RE: Johnson Ag Utility Barn

TO: All Staff
FROM: Public Works Plan Review Team
DATE: July 18th, 2024
SUBJECT: SE-24-00021 Johnson Ag Utility Building

RE: 202402833, SE-24-00021

SUBJECT: WDFW COMMENTS ON SE-24-00021 JOHNSON AG UTILITY BUILDING

CIVIL SITE PLAN

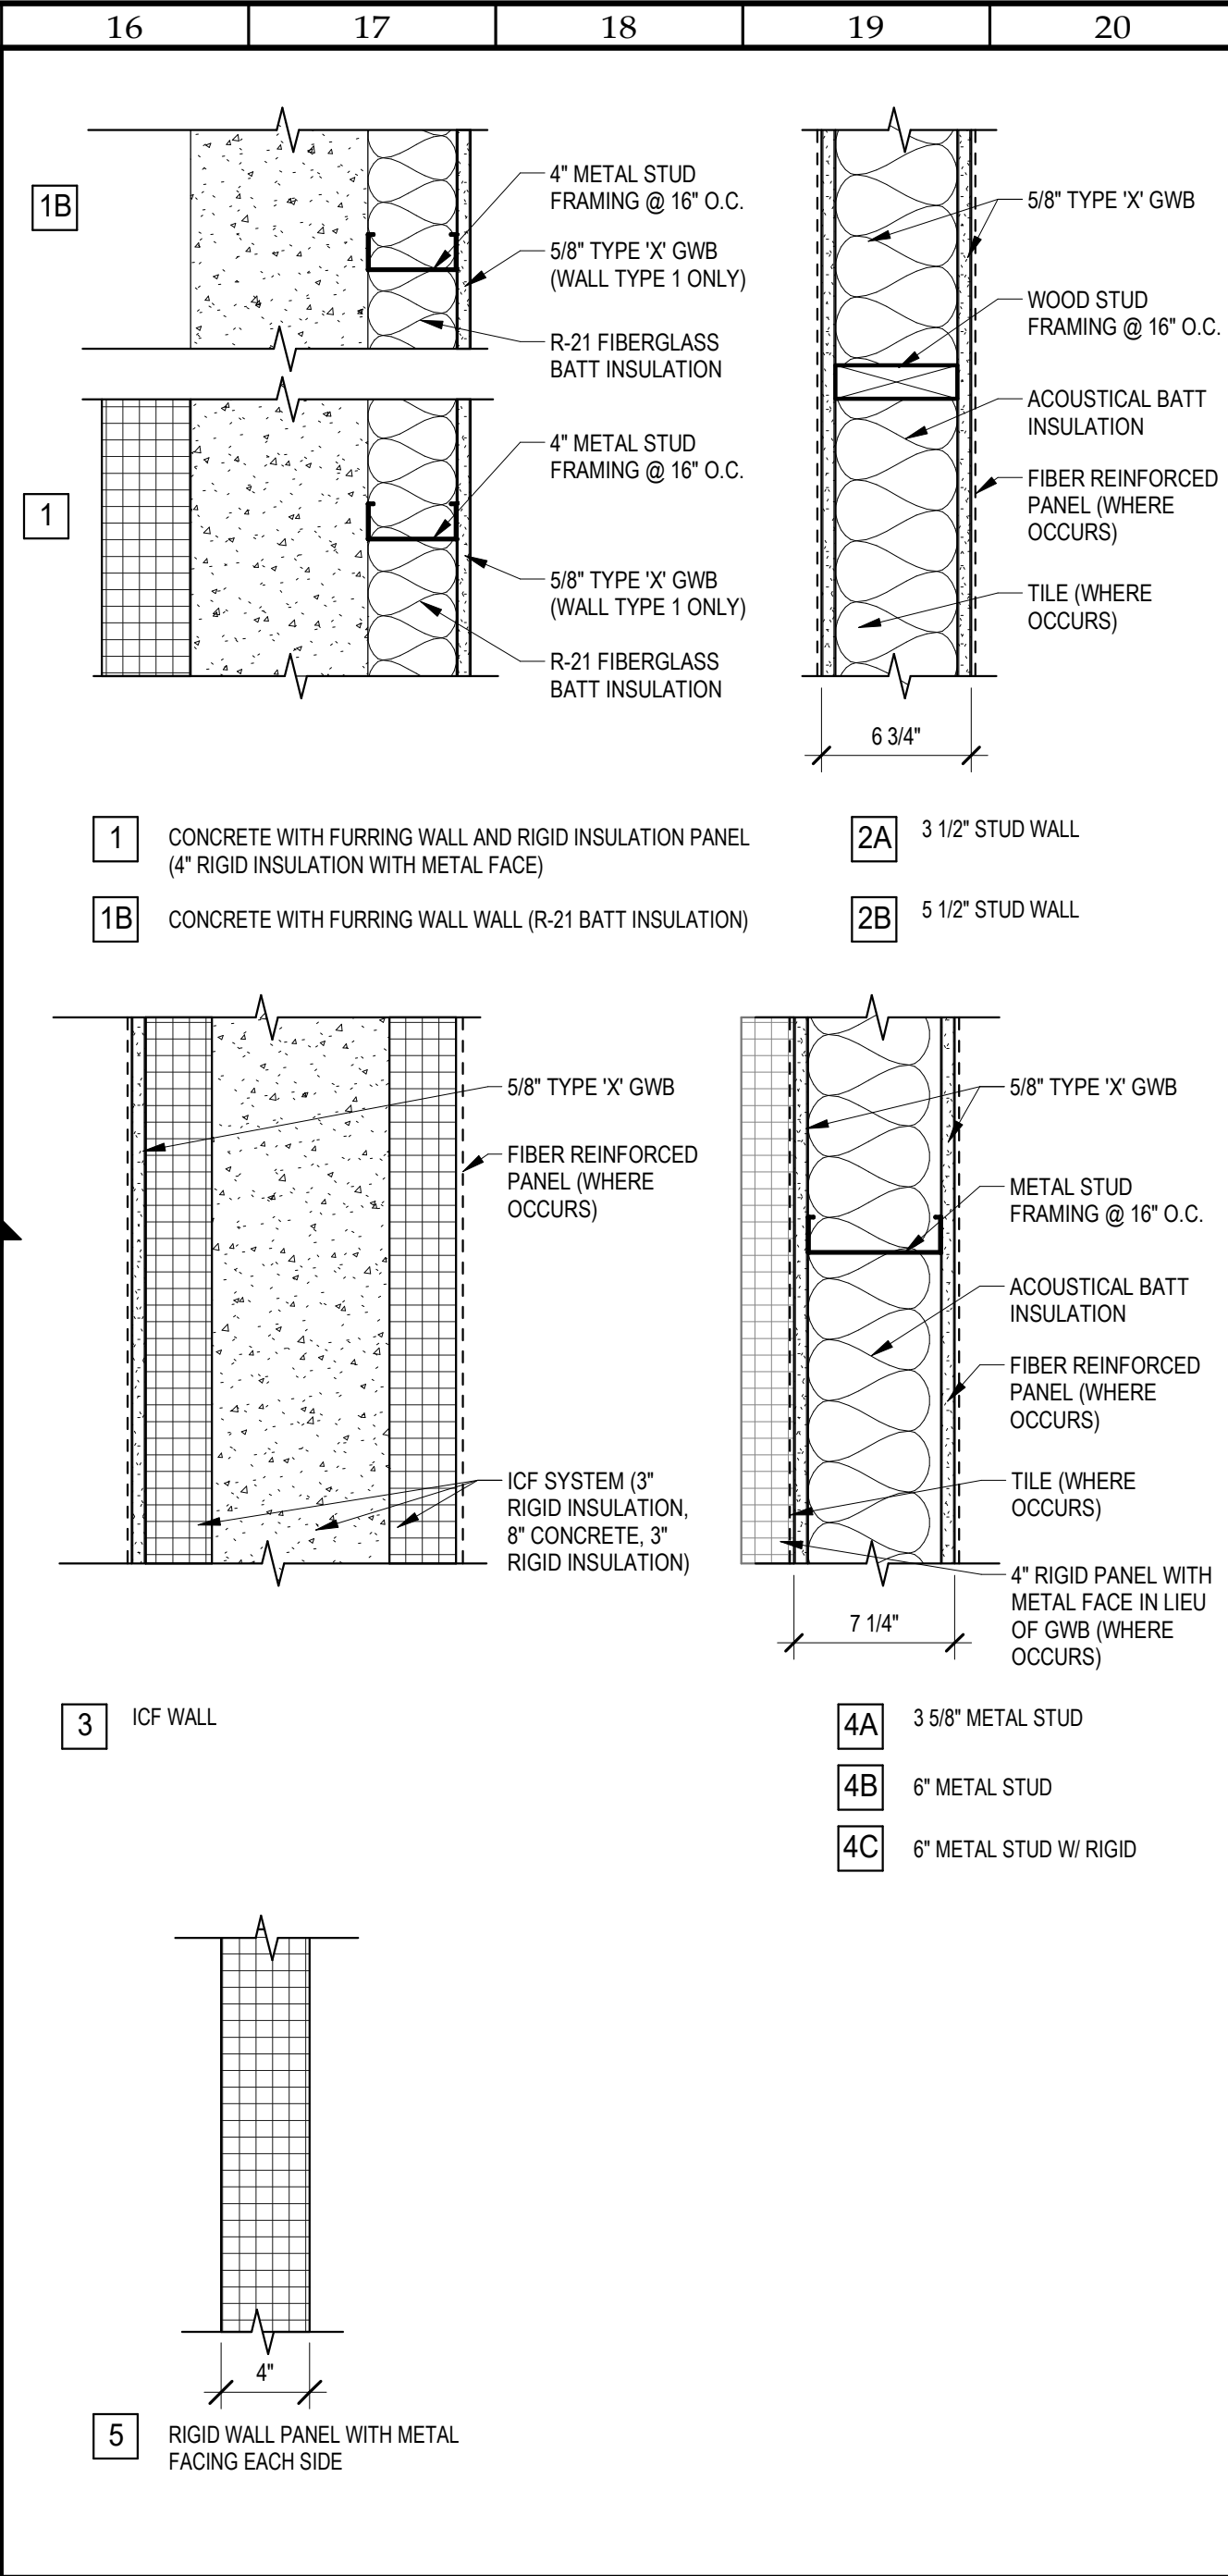
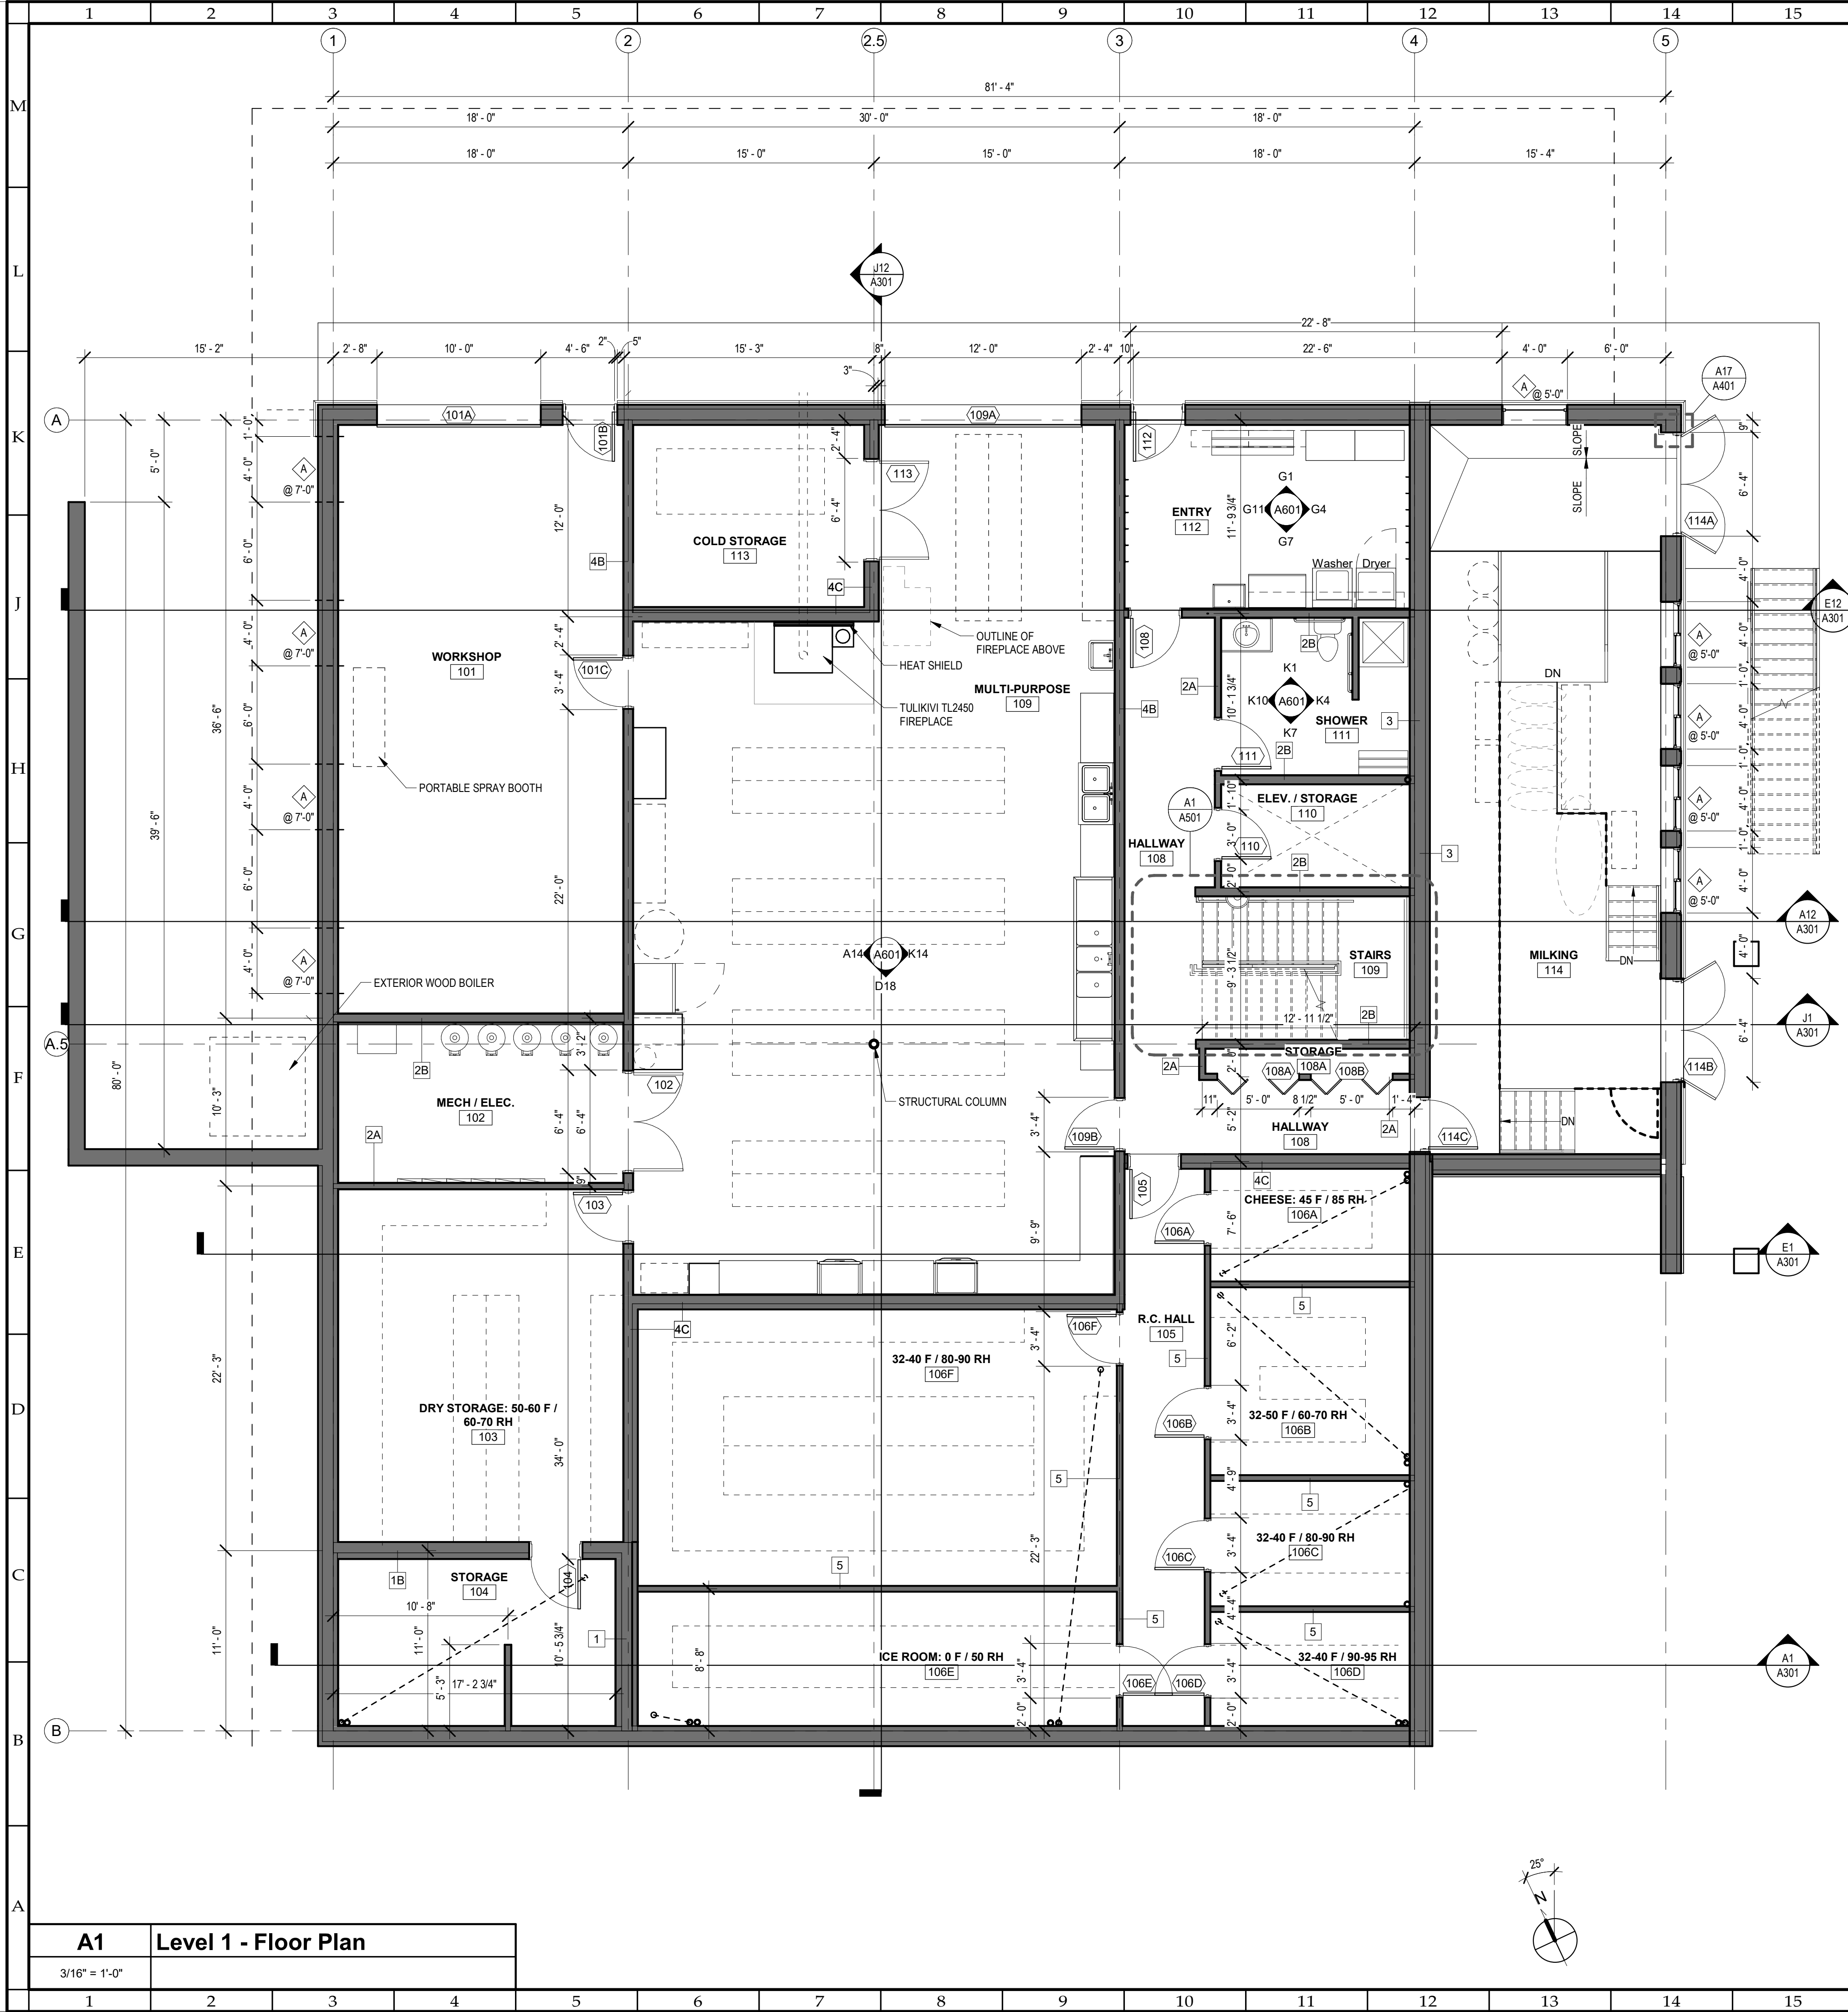
SURVEY	The provided documents included in the application do not adequately identify the West boundary of the subject parcel. From the information provided, it appears that the proposed barn may encroach or trespass on the parcel to the West. If the applicant does not wish to provide this information as part of the application, a Land Surveyor shall be utilized for the building layout and confirm it falls within the setback area of the subject parcel. (JT)
TRANSPORTATION CONCURRENCY	No Comments.
FLOOD	<p>Most of this property is located within the 100-year floodplain and floodway. All construction, including structures that are exempt from a building permit, must follow the guidelines within KCC 14.08.</p> <p>The floodway is highly restricted, and any development must demonstrate no rise in the level of the 100-year flood before being permitted. No new or substantially improved residential structures are allowed within the floodway.</p>

<p>All of the proposed development must be located outside the floodway and a certified survey of the parcel showing the location of the floodway is necessary to establish that the building will not encroach upon the floodway.</p> <p>Please call the Kittitas County Public Works at (509)962-7523 to discuss this project and permitting requirements. (SC)</p>
WATER MITIGATION/ METERING	Per KCC 13.35.027 all new uses of ground water require mitigation and metering. Proof of mitigation is required prior to applying for a building permit. (SC)
AIRPORT	N/A

The property is located in the Rural Conservancy shoreline designation which has a buffer of 100' to the Creek. We also have concern that the site plan does not show the existing access to the construction site, nor other required information do determine if work in the buffer will be necessary to modify the existing access for construction of the new structure. If so, this work may trigger the need for additional shoreline review.

FIRST FLOOR PLAN

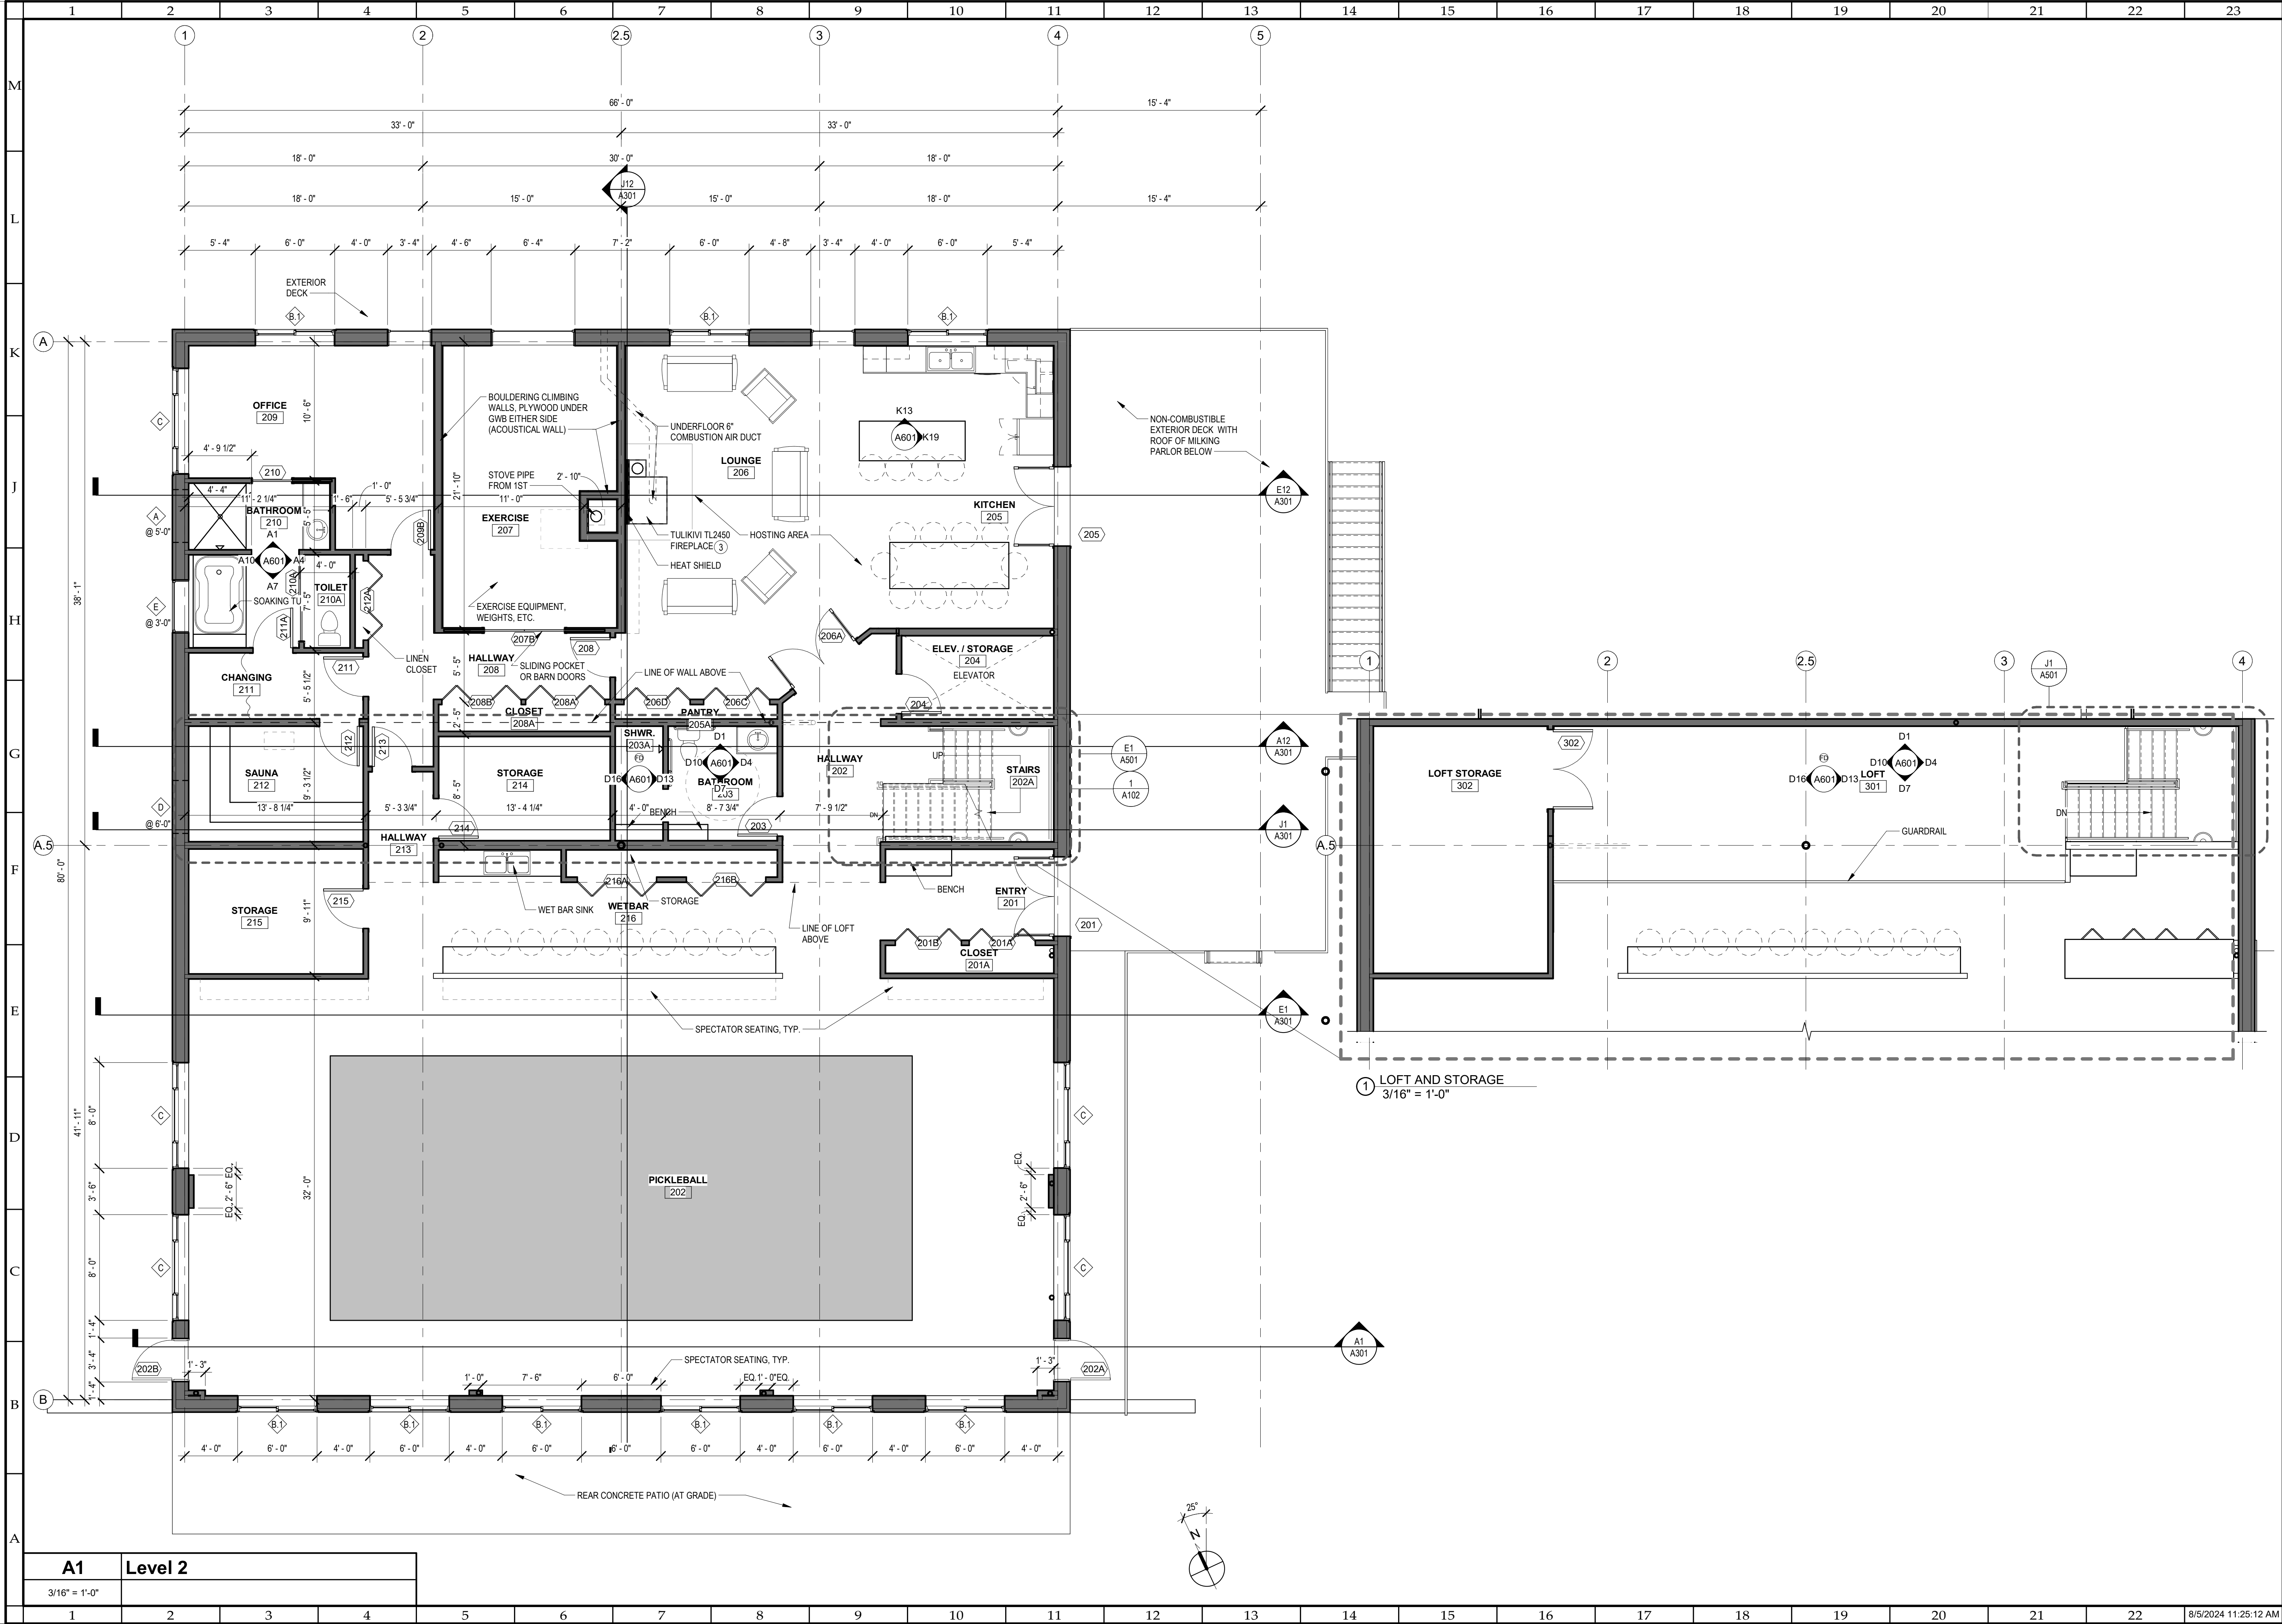
There is some confusion around the use of the structure. The application defines the structure as an "ag utility" building, however some of the application materials identify the structure as a "barn-style residence." The application states that a shoreline exemption will be attained to satisfy the requirements of the Kittitas County SMP, our concern is that this structure does not qualify for an exemption and may require a Shoreline Substantial Development (SDP) instead depending on the use of the building. In section 8 of the SEPA checklist it states that the site does not include working farmlands. Being neither working farmlands nor a Single Family Residence we need clarification as to what exemption this structure qualifies for.
